Ribble Valley Borough Council
Housing & Development Control

App. no: **3/2025/0801**

Address: **Land to east of Salesbury View Wilpshire**

Proposal: **Proposed erection of new residential development comprising 80 new homes, including 30% affordable housing, open space and associated infrastructure.**

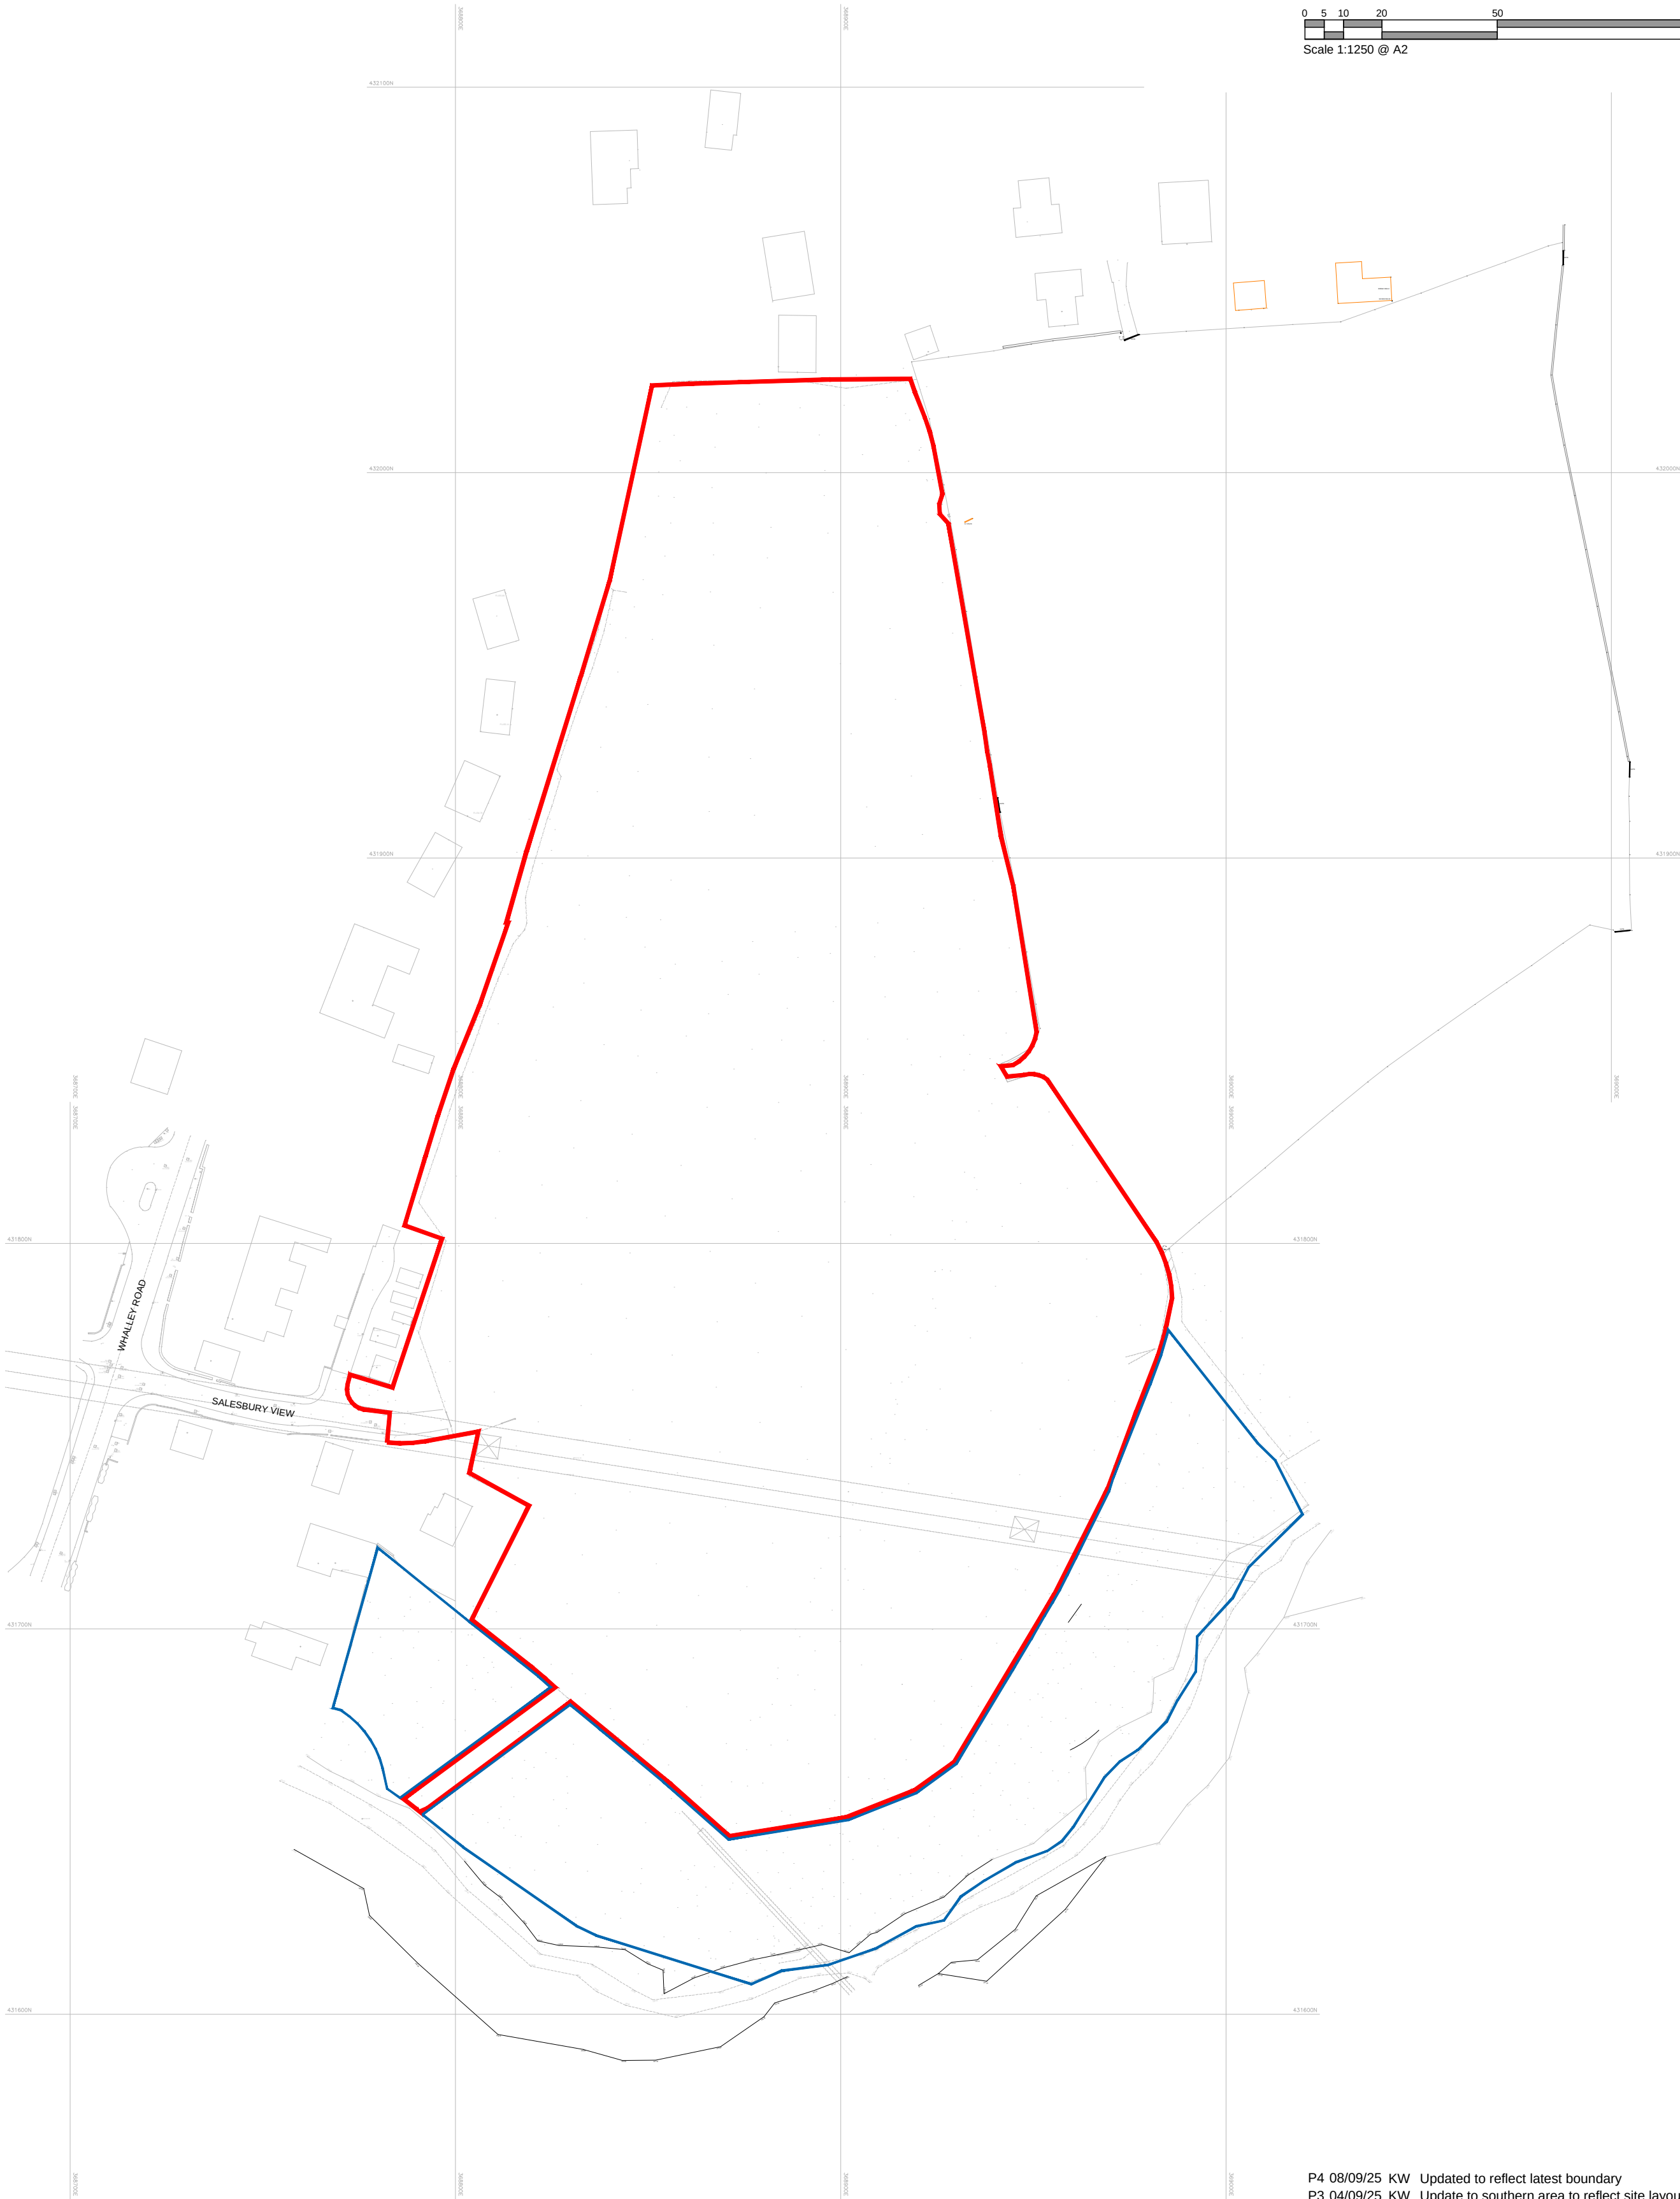
We would request that the footway width is increased to minimum 1.8m outside plots 69-70. Subject to this the layout is to adoptable standards.
